Application No: AL/42/21/HH
Site Address: 32 Lime Avenue Westergate Chichester PO20 3UF
Description of works: Erect a fence along the east side boundary

Thank you for your internet representation made on 2nd June 2021 which has been recorded as an objection with the comments as follows:

Proposed Fence Line
Marked in Red

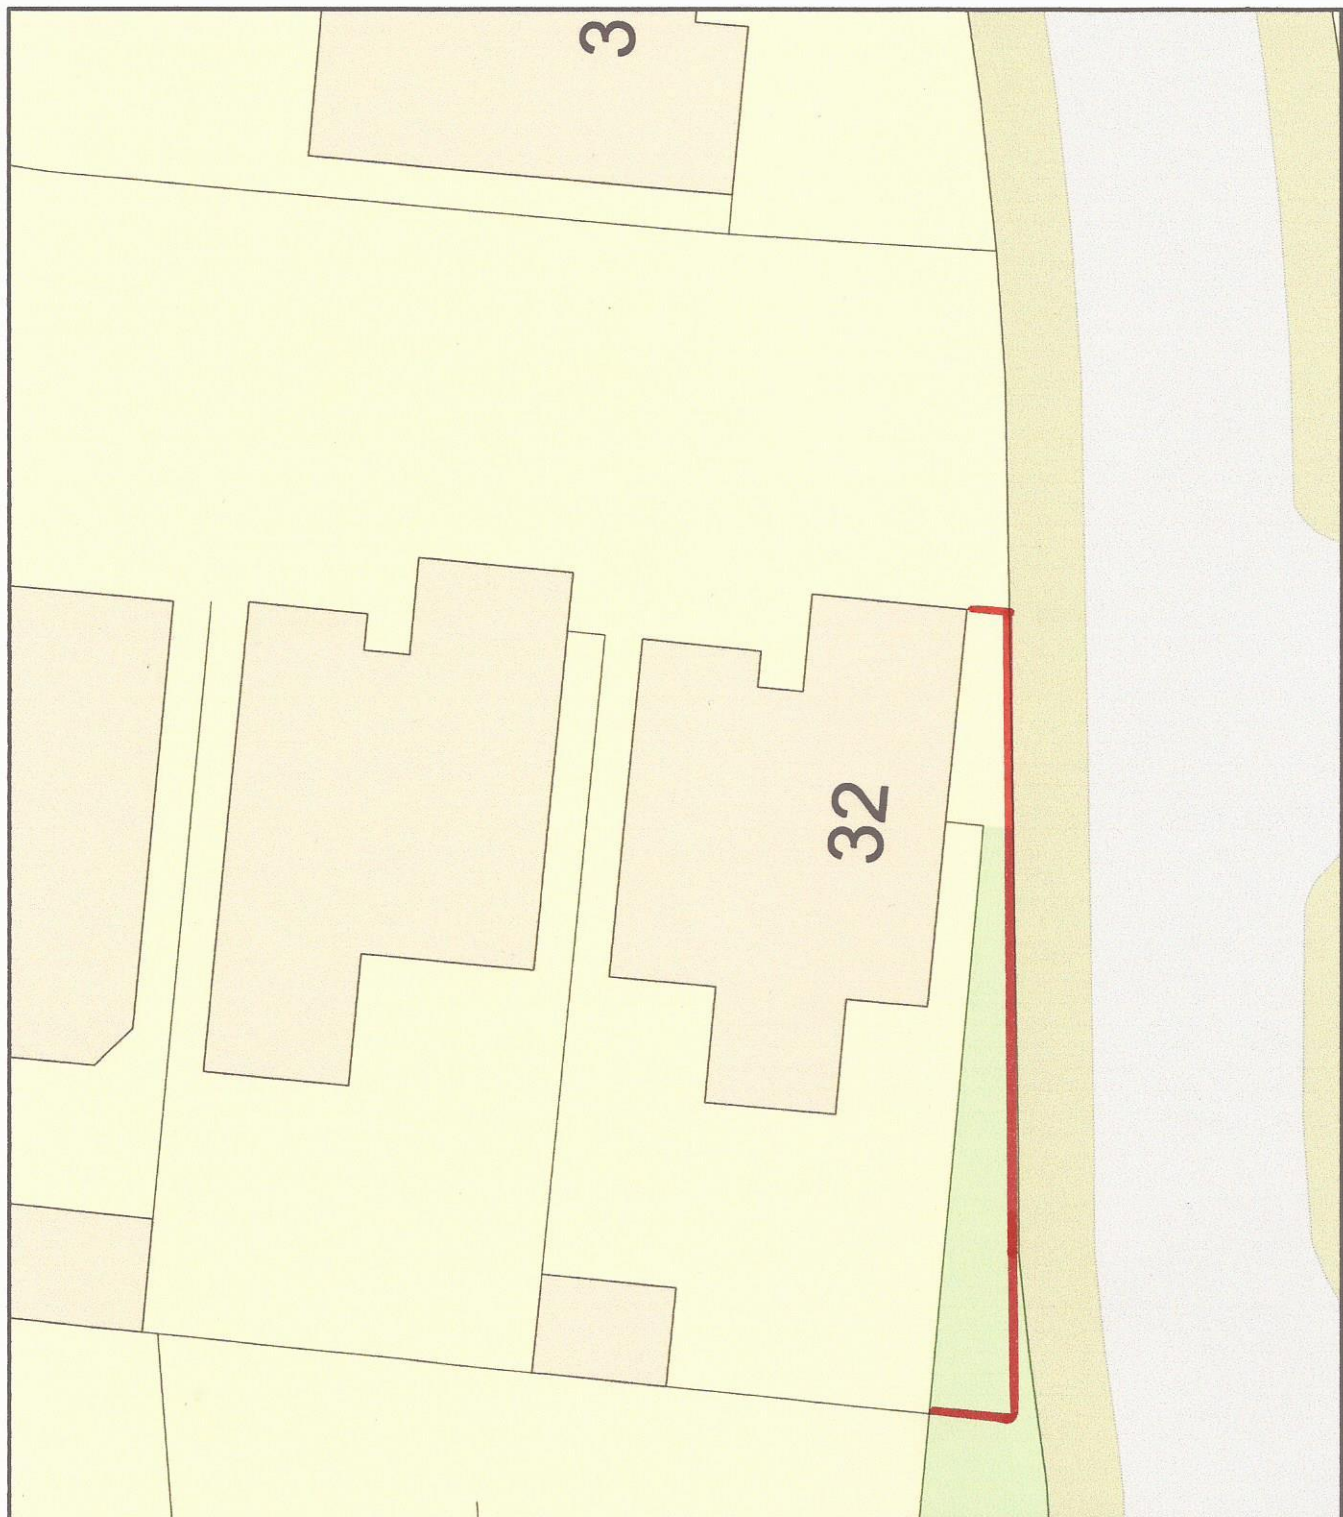
2. We feel that the proposed fence will detract from the visual amenity of Lime Avenue and create a less attractive place to live. Item 2 in schedule 3 of the title deeds is there to protect the open space and we feel strongly that this should be maintained for the benefit of all residents.

3. The proposed line of the fence will limit and restrict the view to the right as you leave the shared driveway that serves Nos 32 to 36, Lime Avenue. We feel that this will create a hazard to road users and pedestrians. This is further compounded by the fact that the residents at No 32 Lime Avenue also park a large truck at the entrance to the shared driveway, which is in contravention of item 11 in schedule 3 of the title deeds, and further restricts the view to the right.
